National Infrastructure
Planning
Temple Quay House
2 The Square
Bristol, BS1 6PN

Our Ref: EN010107

Application by EP Waste Management Limited for an Order Granting Development Consent for the South Humber Bank Energy Centre Project

Advice following issue of decision to accept the application for Examination

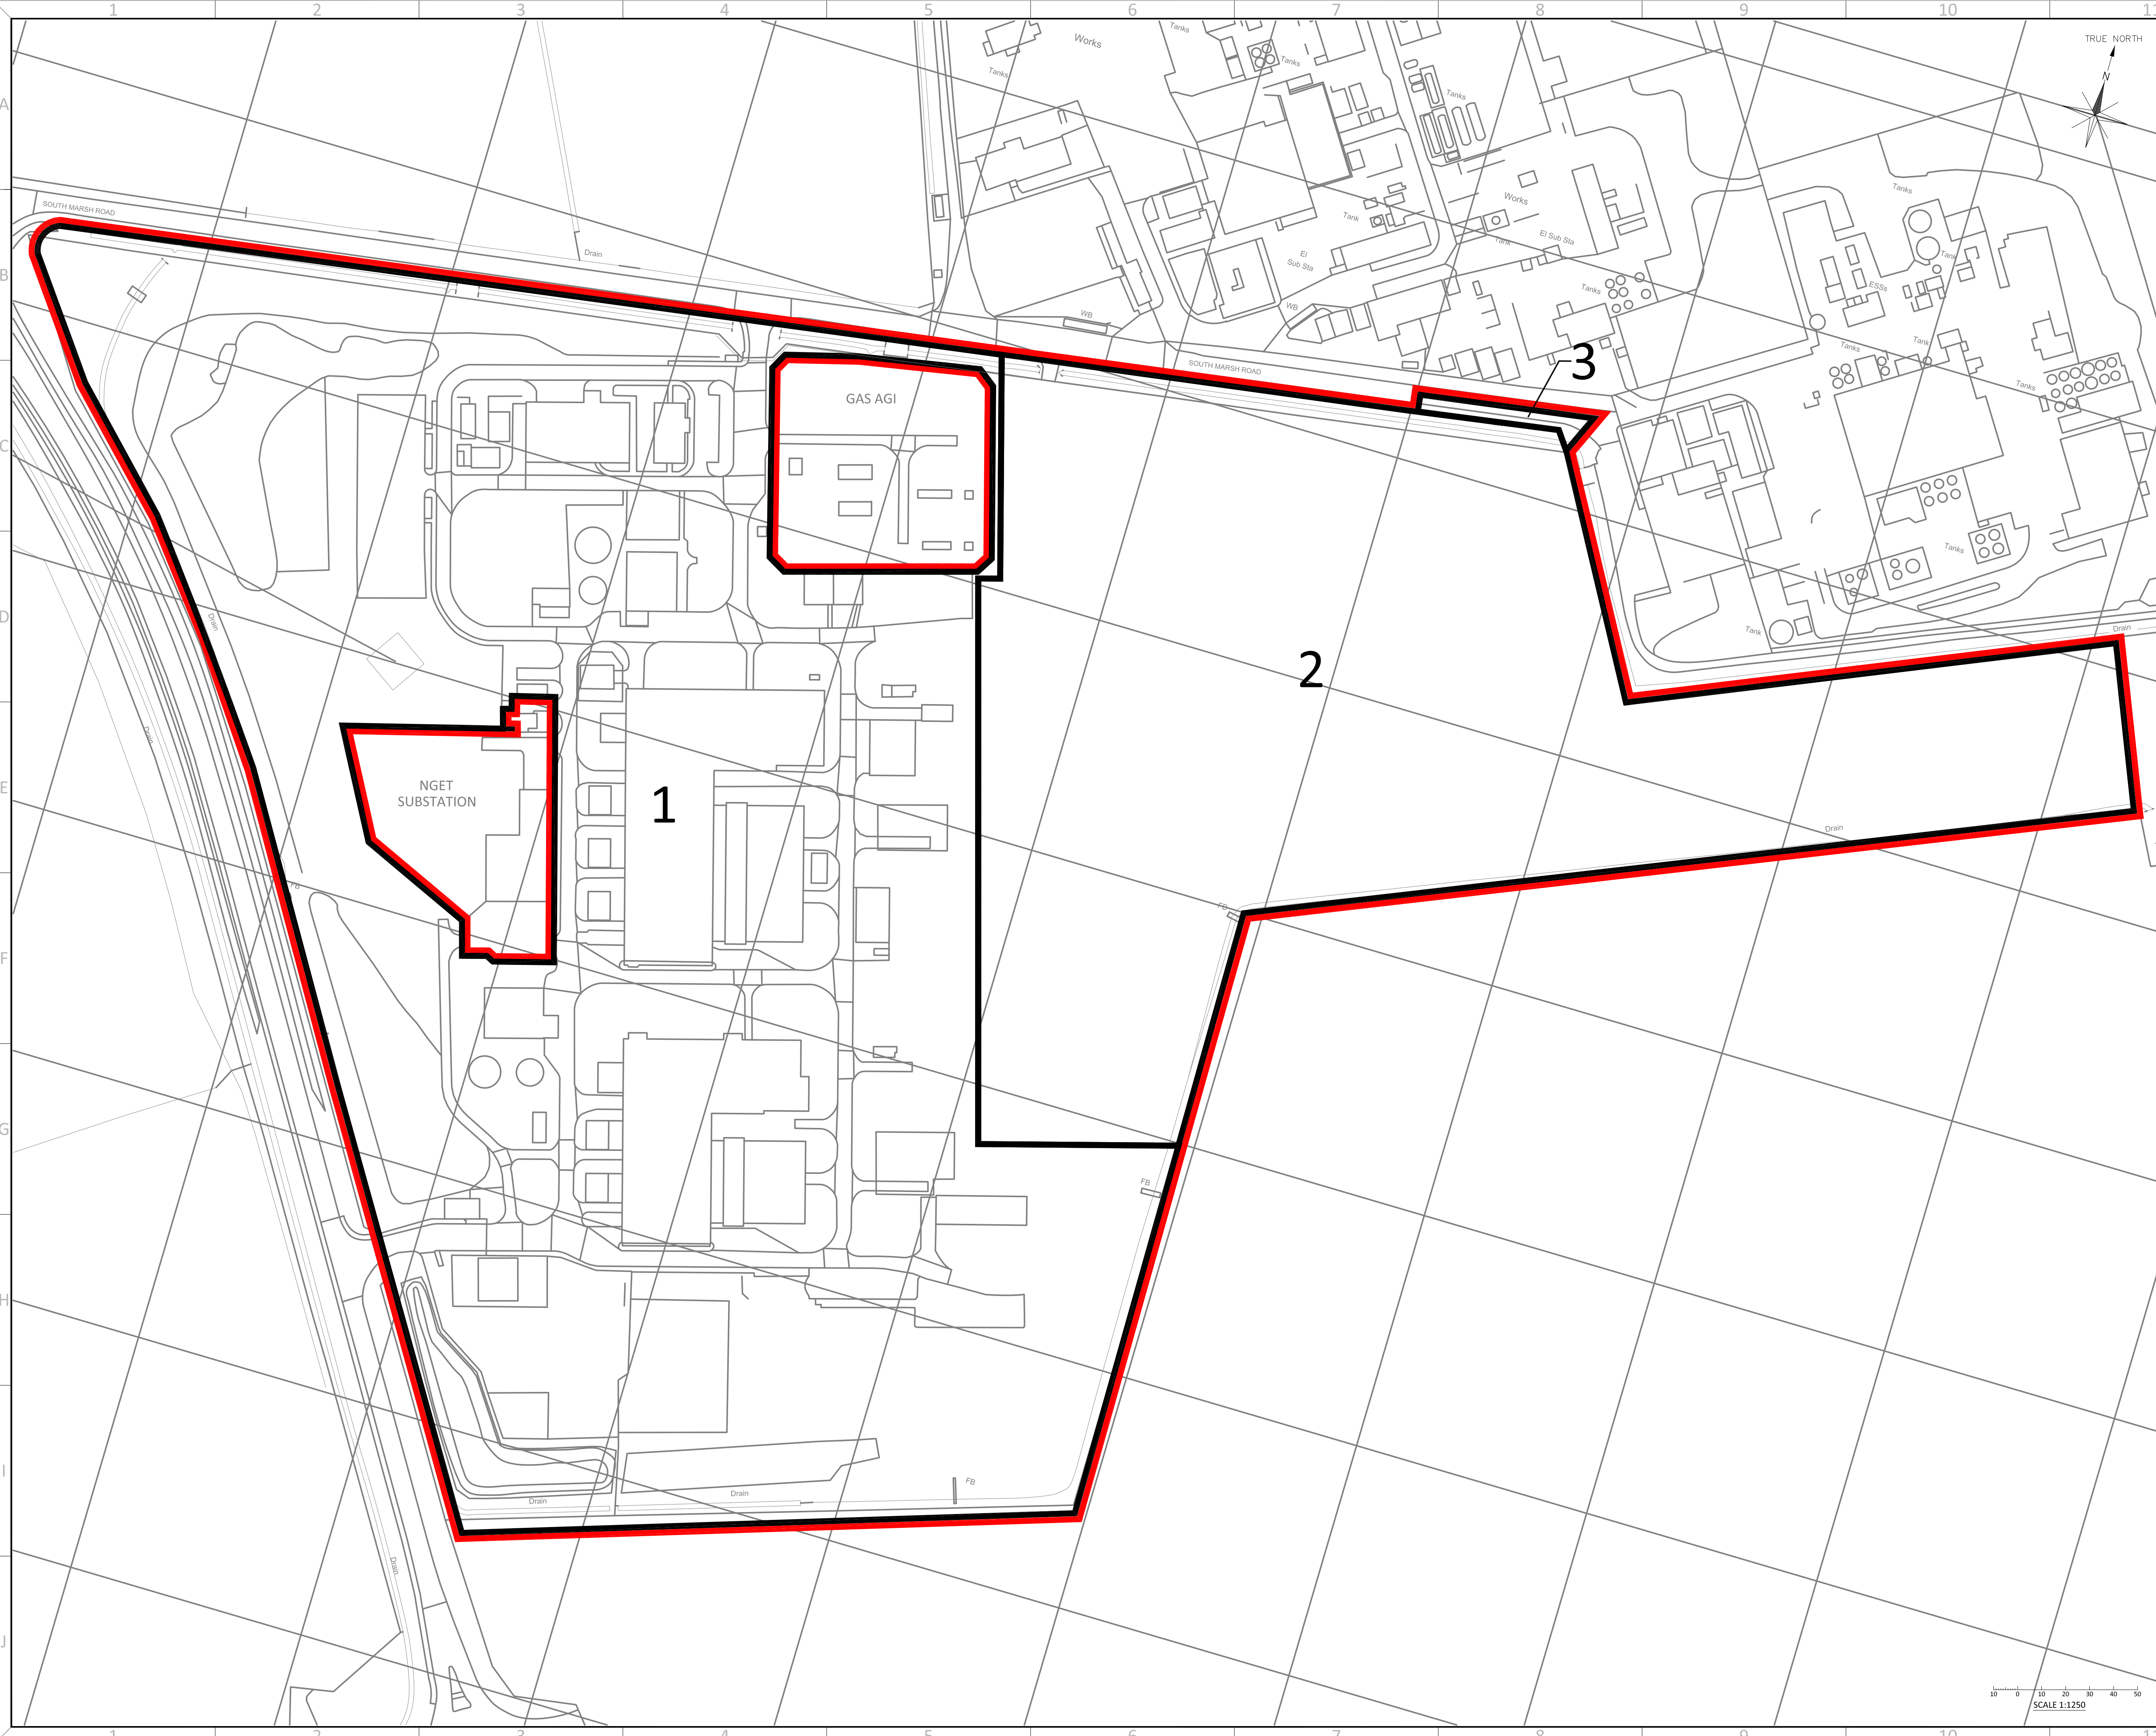
It would be helpful, to assist the examination, if the black line denoting Plot 1 could be drawn to exclude the AGI and substation, which are not within the Order Limits.
